**Consultation Response from KC,
Lead Local Flood Authority****2025/93299 Centre 27 Business Park, Bankwood Way, Birstall, Batley, WF17 9TB****Discharge of details reserved by condition 8 (drainage) on previous permission 2025/91401 for variation condition 2 (plans) on previous permission 2024/93522 for variation conditions 2, 7, 12, 13, 14, 15, 16, 20 on previous permission 2023/93781 for demolition of existing buildings and erection of coffee shop with drive thru facility; drive-thru restaurant (Class E and Sui Generis); flexible commercial unit (Class E (a) and/or Class E (b) and/or hot-foot takeaway Sui Generis use); formation of hard and soft landscaping works; modifications to access and associated works****Date Responded: 06/01/2026.****Responding Officer: Martin Stephenson****Responding Ref: 1****Previous response by the LLFA**

Discharge of Drainage Conditions

Drainage Summary:**Condition 8:**

TITLE	
PROPOSED SURFACE WATER DRAINAGE LAYOUT

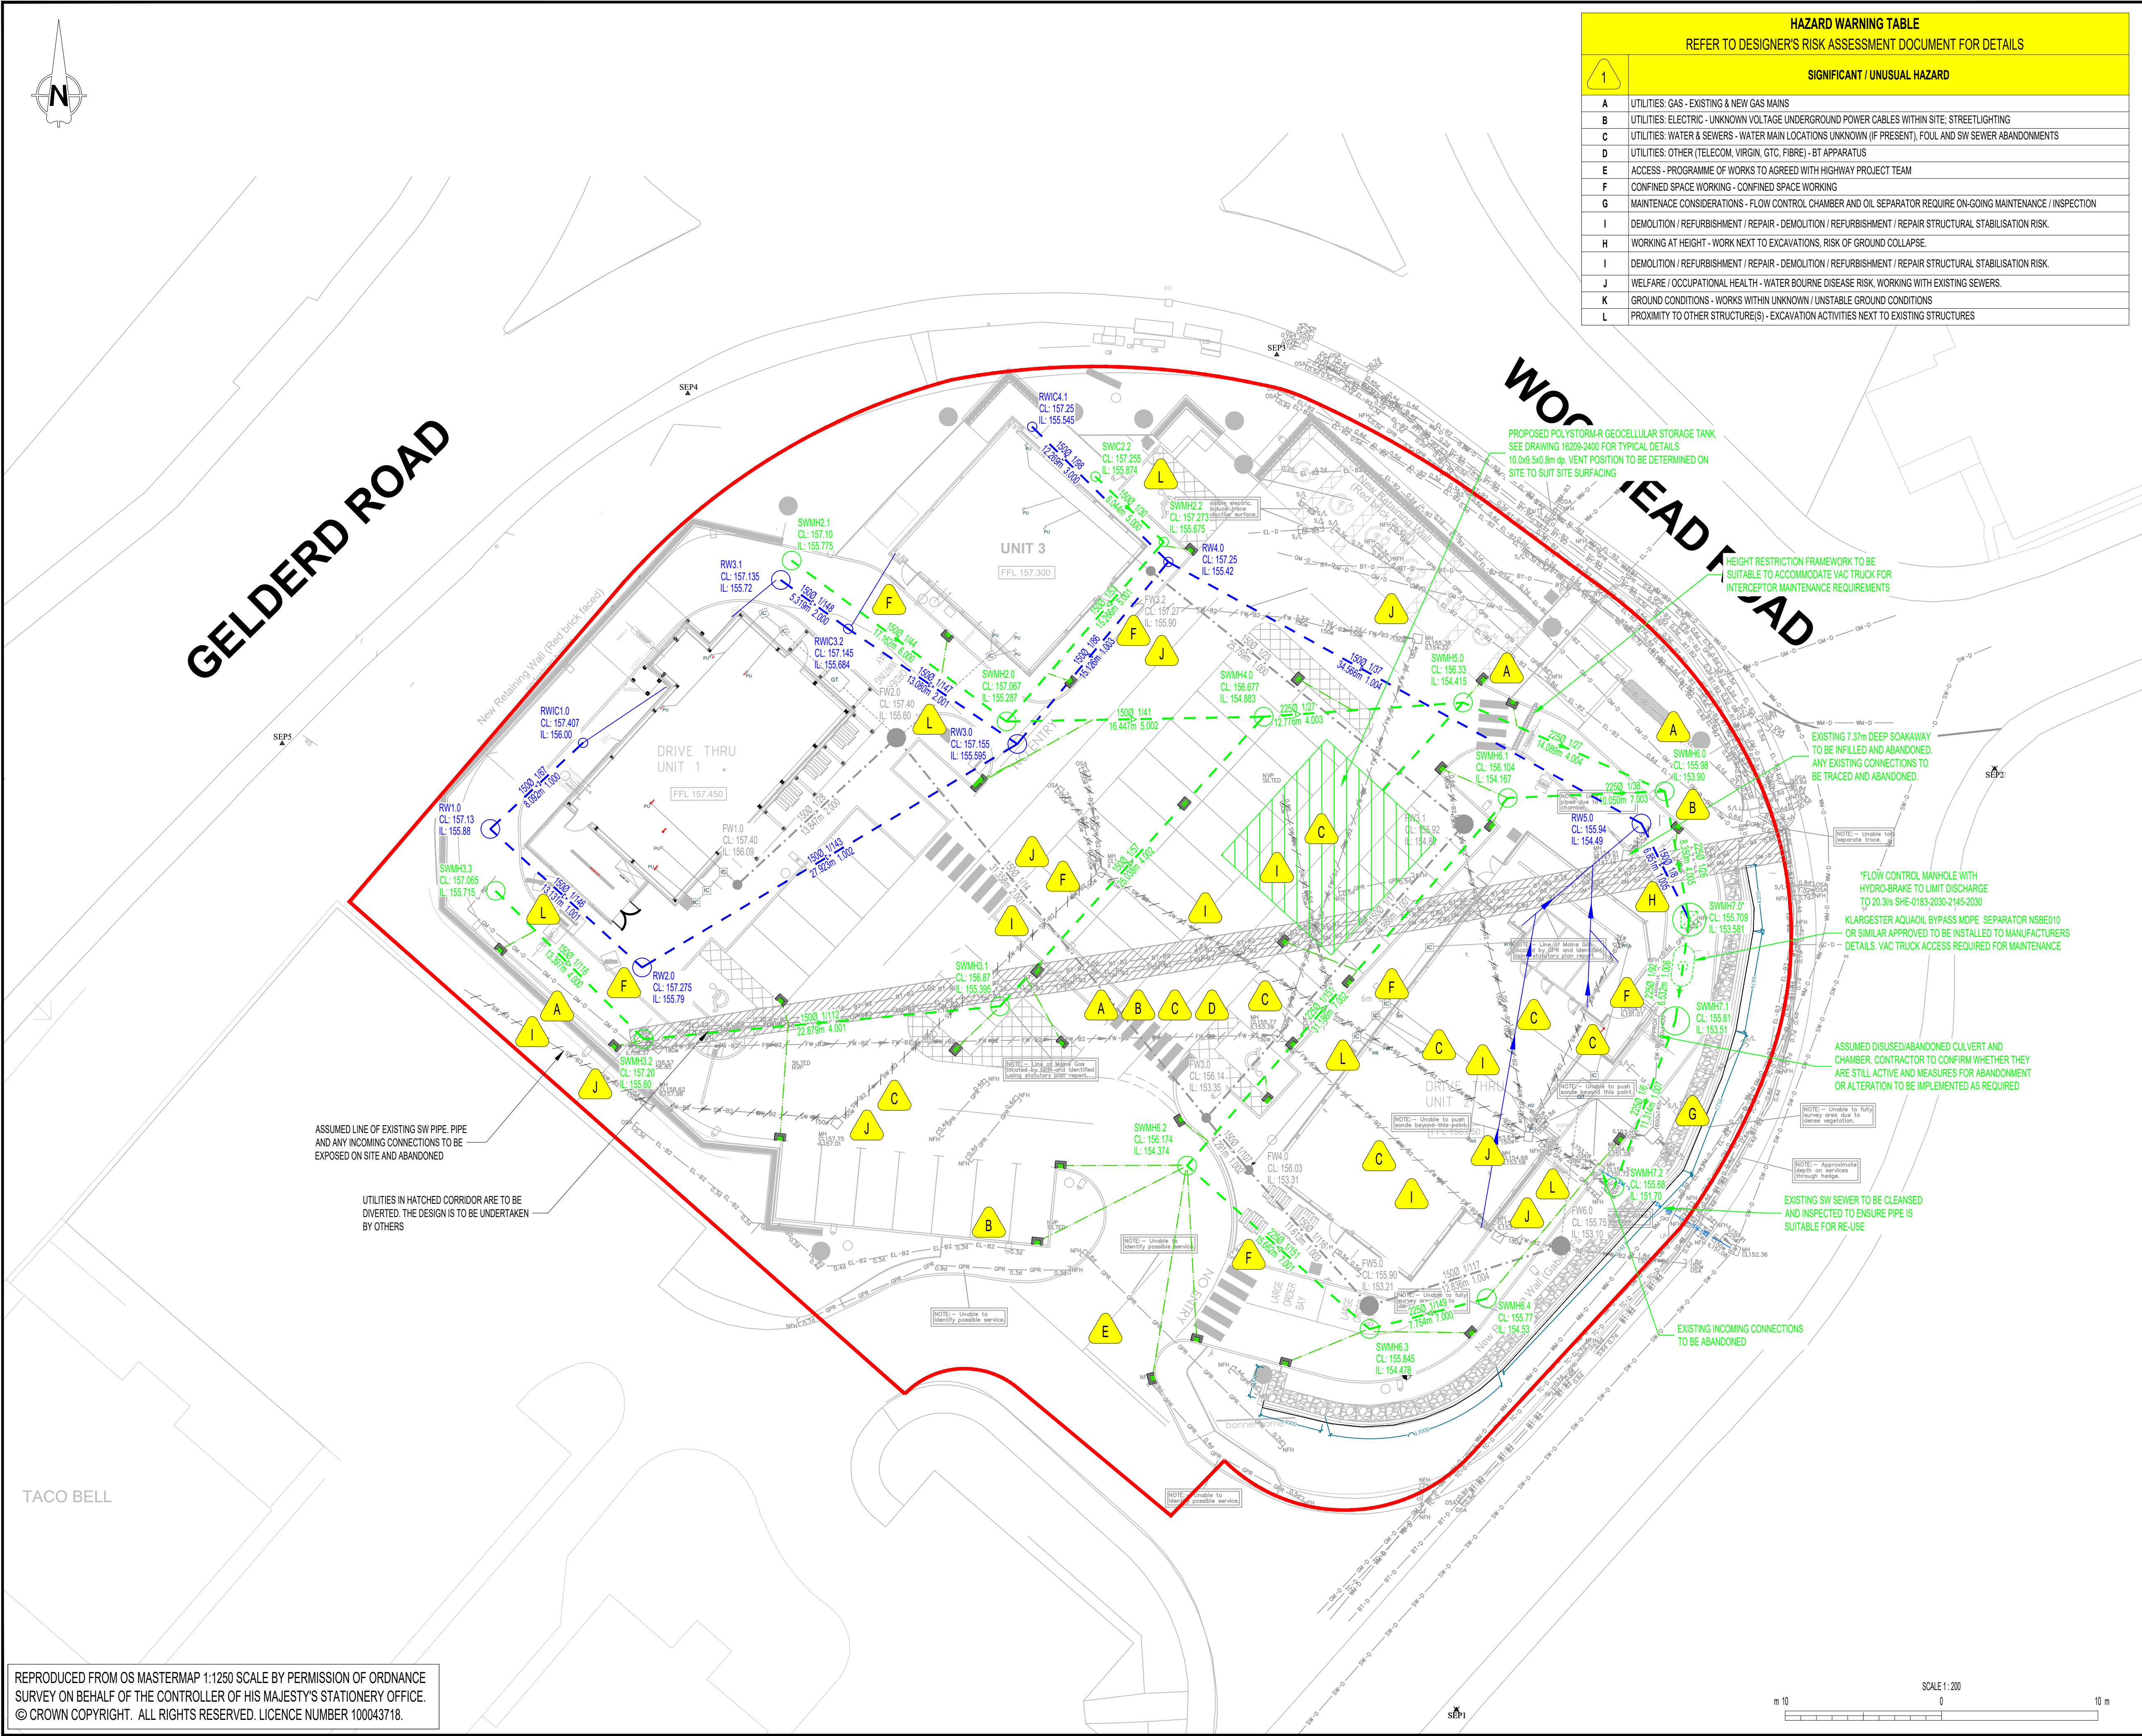
The SW Drainage Layout drawing appears to show both roof and hardstanding drainage passing through the oil separator. This is not good practice as the roof water could flush out any retained oils.

No access into the attenuation tank is shown – how will the tank be inspected and maintained?

MH SWMH5.0 should be of the silt trap type to minimise the risk of siltation in the attenuation tank.

The invert level of the attenuation tank is not noted on the SW Drainage Layout drawing. There should be a self-cleansing gradient in the pipe from the tank to the connecting MH to ensure the tank fully empties after rainfall.

MH SWMH7.2 does not appear to be located over the existing drain to the YW SW sewer.

TITLE
PROPOSED FOUL DRAINAGE LAYOUT

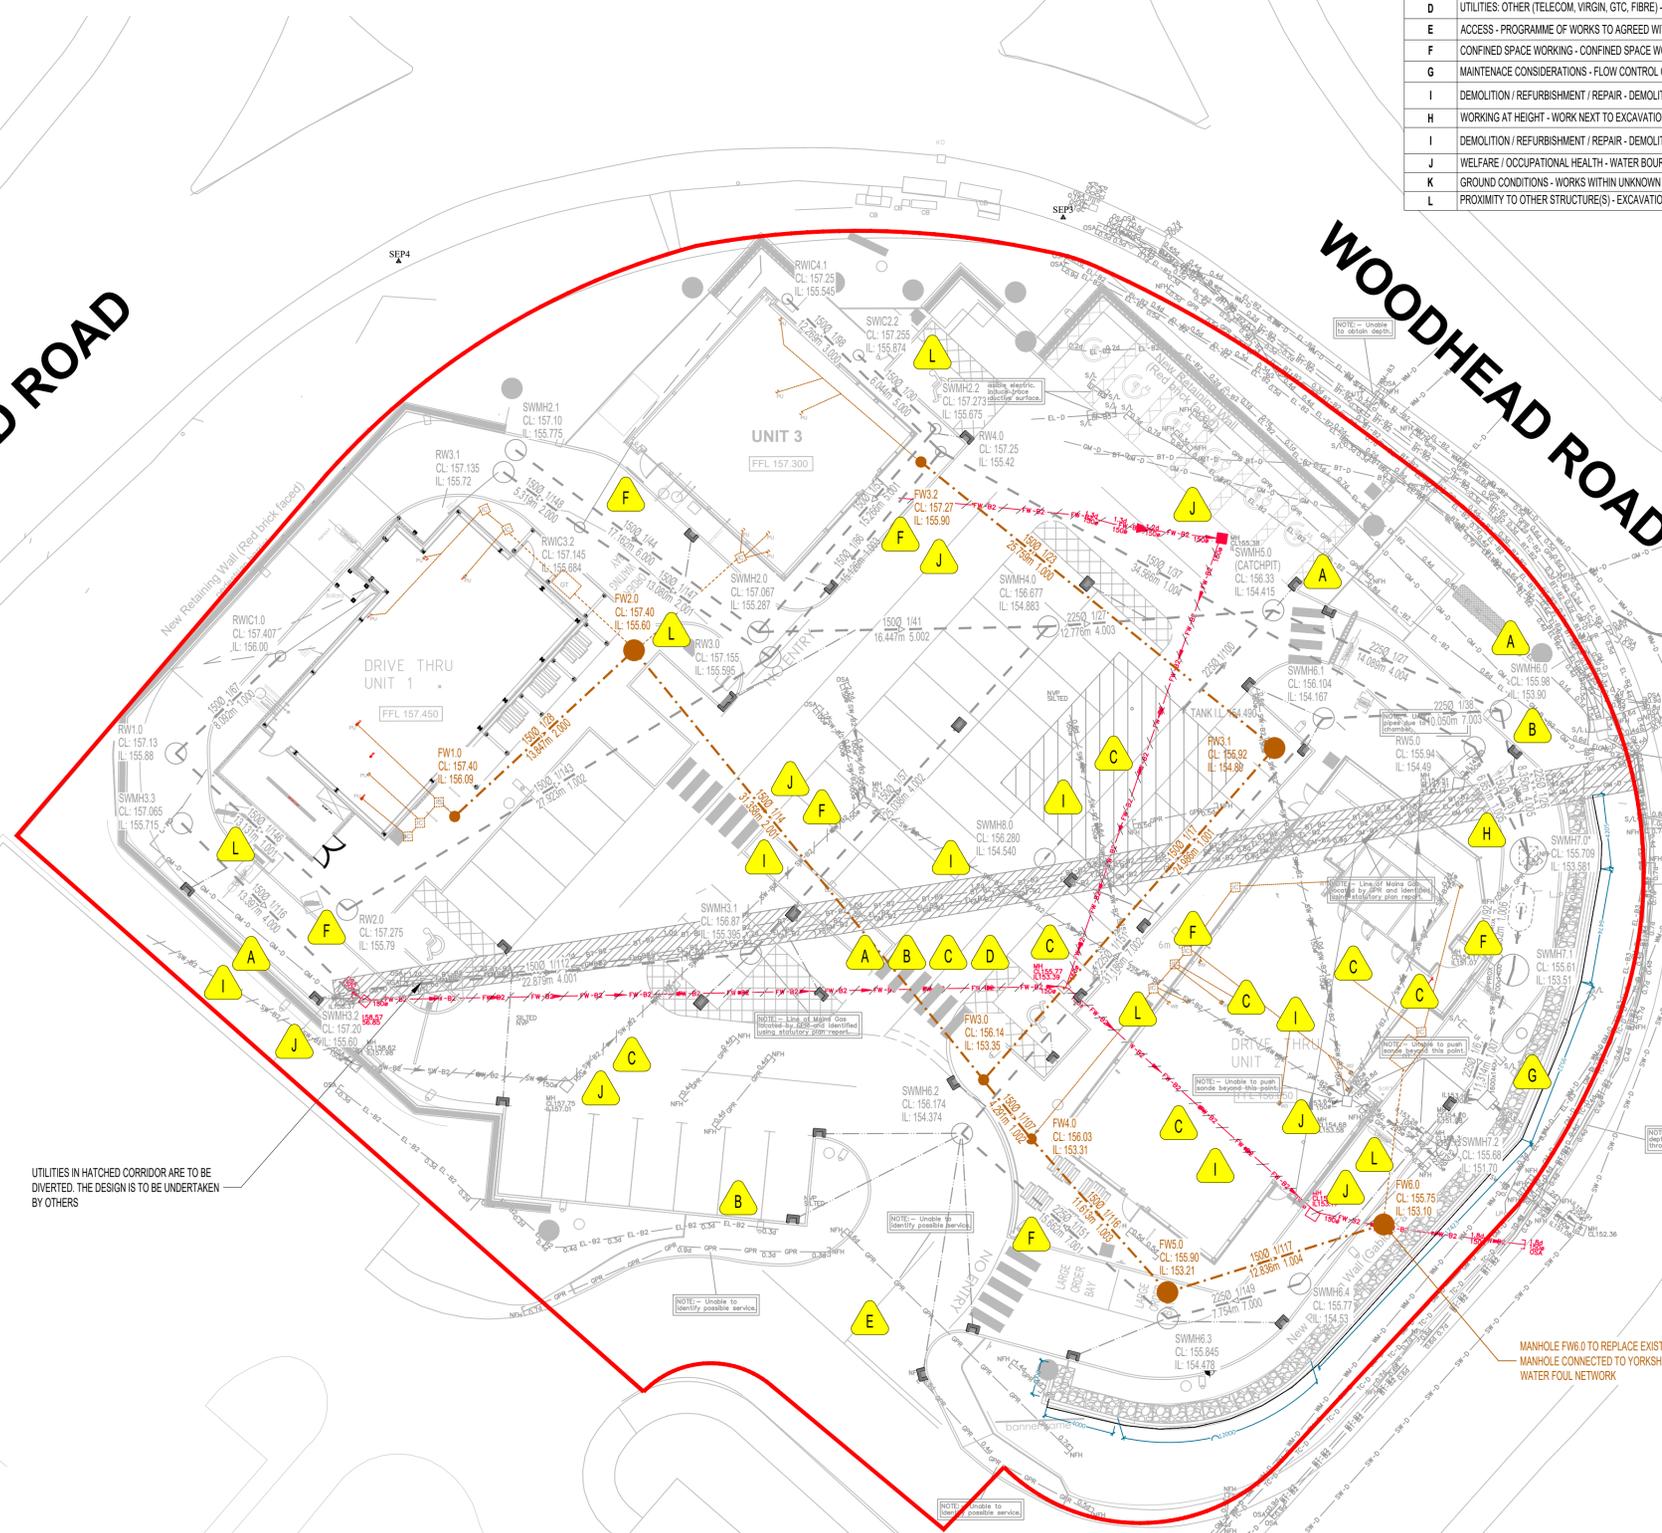
The proposed foul drainage appears to discharge to the Yorkshire Water Surface Water Sewer in Woodhead Road – has this been agreed with YW?
